Appendix D Supplementary responses

COMMENTS REGISTER			
Project Name:		Panorama BESS	
Client Project Manager:		Christopher Smith	
SLR Project No:		660.v30234.00003	
SLR Project Manager:		Charlie Seventekin	
Revision:		v1.0	
Revision Date:		Wednesday, 16 April 2025

ARES PROJECT SERVICES PTY LTD - ABN: 45 643 587 115

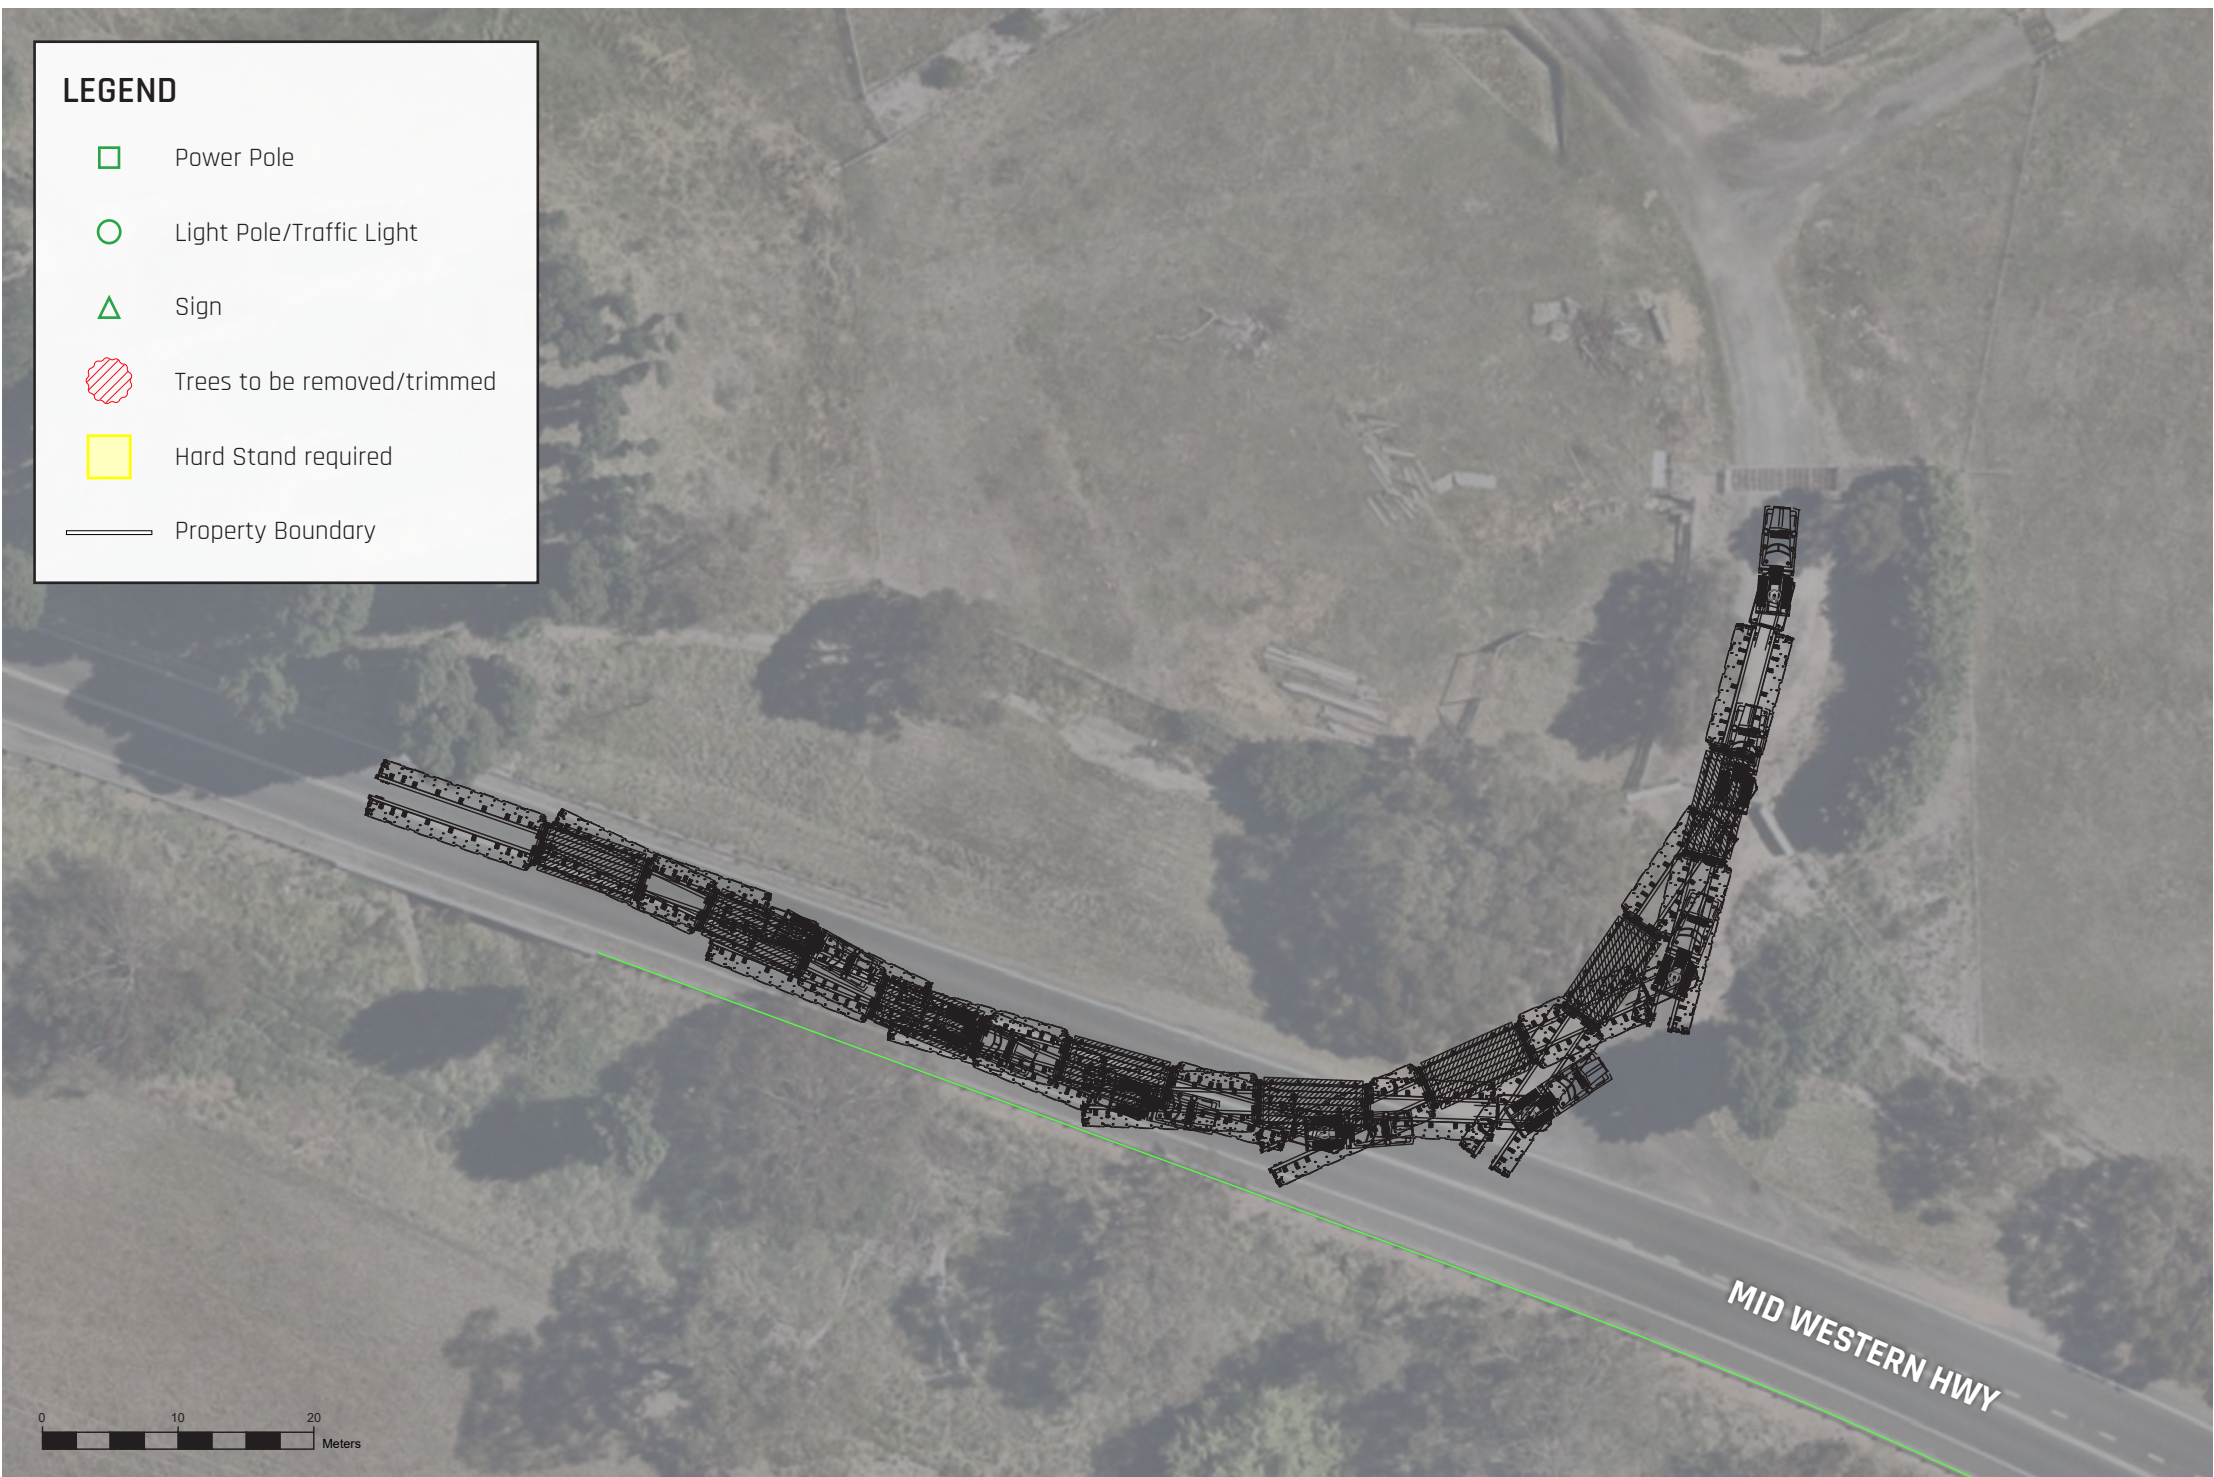
6	OSOM vehicle for the transformer is classified as high risk OSOM (as defined on TfNSW website in this link) due to its proposed height exceeding 5.20m. A Concept Level Route Analysis is required with the following information: • The route from port or point of origin to site access and intersections required to facilitate high risk OSOM movements required for the project. • Details of all high risk OSOM loads and vehicle configurations for the project. • Location of pull-over bays / rest areas along the high risk OSOM routes (including GPS coordinates) and demonstration swept paths of high risk OSOMs can be physically accommodated (in terms of size, width and accessibility). • Road geometry details and alignment along identified transport route(s), including existing formations, crossings, bridges, intersection treatments and any identified hazards, including: o Bridge Assessments for any at risk bridges on the classified road network due to dimensions and weight of OSOM vehicles. o Swept path analysis demonstrating the largest design vehicle can enter and exit the site and simultaneously pass through intersections along the proposed transport route(s). o Design vehicle templates used in the swept path analysis software in order for TfNSW to review performance (e.g. Autodesk Vehicle Tracking or Transoft AutoTURN). o Highlighting each at-risk road structures that haulage route(s) cross including bridges, traffic signals, signage, major culverts and minor culverts that may not meet desirable cover to cater for proposed axle loads. • Identify and provide the following measurement parameters of OSOM components / materials to be moved: o Types and numbers of high risk OSOM vehicles. o Overall combination type, configuration, load and vehicle configuration. o Wheelbase dimensions. o Length, width, height and mass (GCM, tare, weight to axle and payload) for components and nominated vehicles. o Maximum trailer articulation angle(s). o Minimum overhang heights above the road surface. o Vehicle configurations. o Traffic mitigation measures or road works, modifications or road upgrades to facilitate the movement of high risk OSOM(s). o Potential high level mitigation measures or commitments to mitigate known traffic, safety and impacts to road users along the high risk OSOM route(s) (i.e school bus routes, mining shift changes, TSRs, harvest periods and events). • Identify and assess implications of any road and rail projects that may be under construction during the indicative schedule for the OSOM movements. Note: NHVR permits do not cover road works or upgrades and environmental approvals required for proposed OSOM route(s). Any road works or upgrades works required along the OSOM route must be included within scope of works in the SSD to ensure constructability. Note: Given high number of renewable energy and other large scale projects requiring haulage of OSOM components on the road network, restrictions and limitations on OSOM movements may be imposed. In this regard, it is recommended you engage early with TfNSW's Development Services Renewables team to discuss the requirements of the route assessment.	ADDRESSED IN SECTION 2.5.4 and Appendix H.	Reference is made to TfNSW request in Section 2.5.4.

Appendix H Strategic Design Drawings and Swept Path Assessments

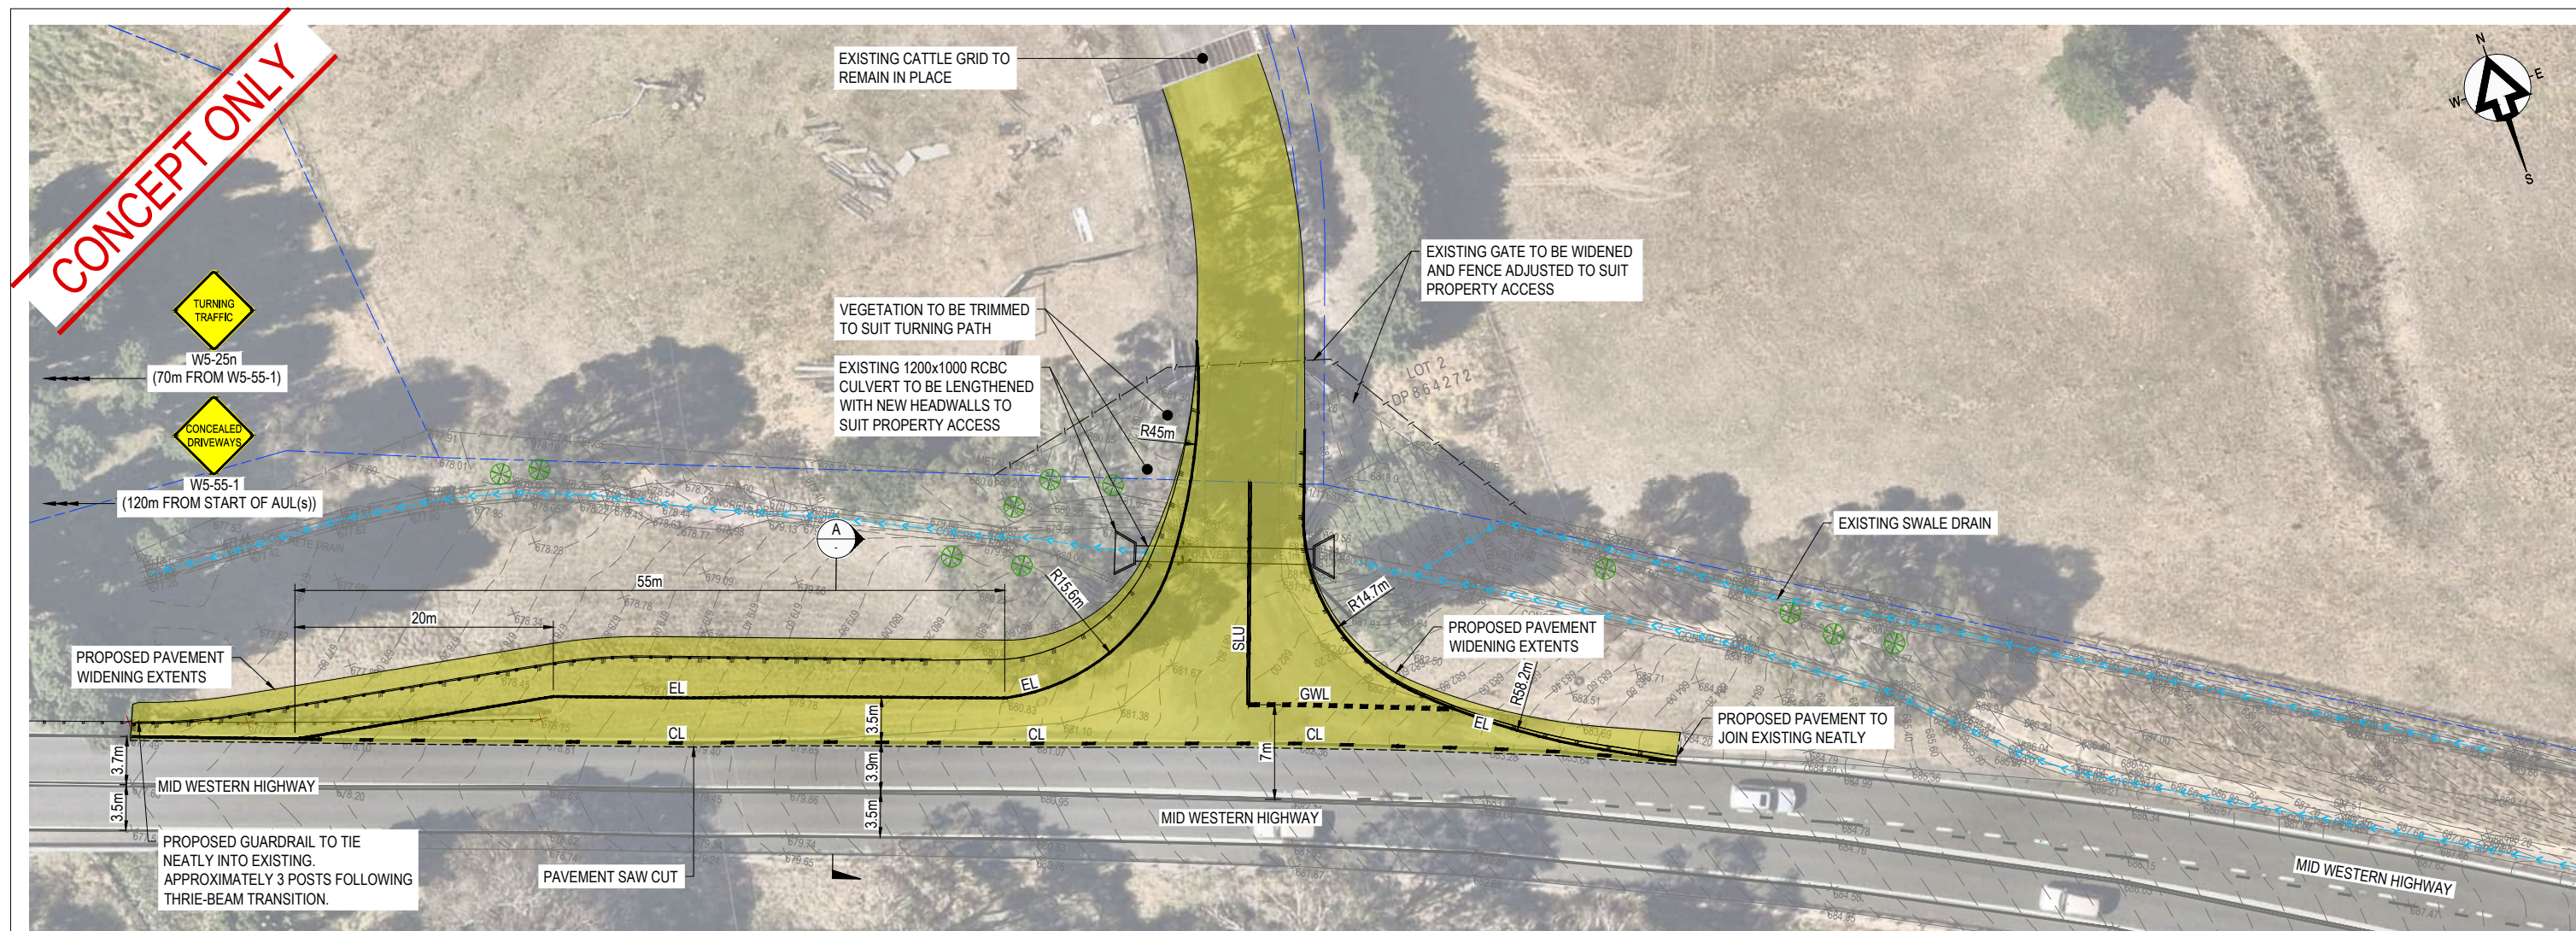
11	Updated plans are required to clearly show site boundary and road reserve based on a survey.	The attached Strategic Design has been undertaken based on the survey data prepared by Metropolis City Surveyors (refer to attached drawing N20879 dated 07/02/2025).	
12	There are concerns over current location of the site access due to the following constraints: •The curve in the road restricts SSID compliance, particularly towards the west. •The site access is located at the bottom of a vertical grade, where speed is likely to be higher, potentially causing issues for heavy vehicles trying to slow down to access the site. •The short distance between the site access and an existing bridge west of the site (approximately 40m). If the above issues cannot be addressed an alternative location to the site will be required. General comments •The use of Evans Plains Road will require consultation with the relevant Council due to being a local road. Please note the TIA states Evans Plains Road is a low-speed road, however as a rural road with no sign posted speed limits the default rural 100km/h speed limit applies.	1. The curve in the road does not restrict the compliance of the required SSID. Please refer to Section 5.1. 2. We reviewed the vertical alignment - the driveway is located at uphill in the eastbound direction. It is downhill in the westbound direction but heavy vehicles are not approaching from that direction. 2. Having reviewed the speed data from the ATC surveys, 85th percentile speeds near the site access (101km/h) are consistent with the posted speed limit (100 km/h), therefore turn SSID is undertaken for 101 km/h (the real speed data). 3. The distance between the site access and an existing bridge west of the site does not prevent the applicant from constructing a BAL arrangement. There is no need to find an alternative driveway location. 4. The Council has raised no issues with the use of Evans Plains Road. It is proposed that heavy vehicles not exceed 60 km/h on Evans Plains Road.	Reference is made to TfNSW request in Section 5.1.
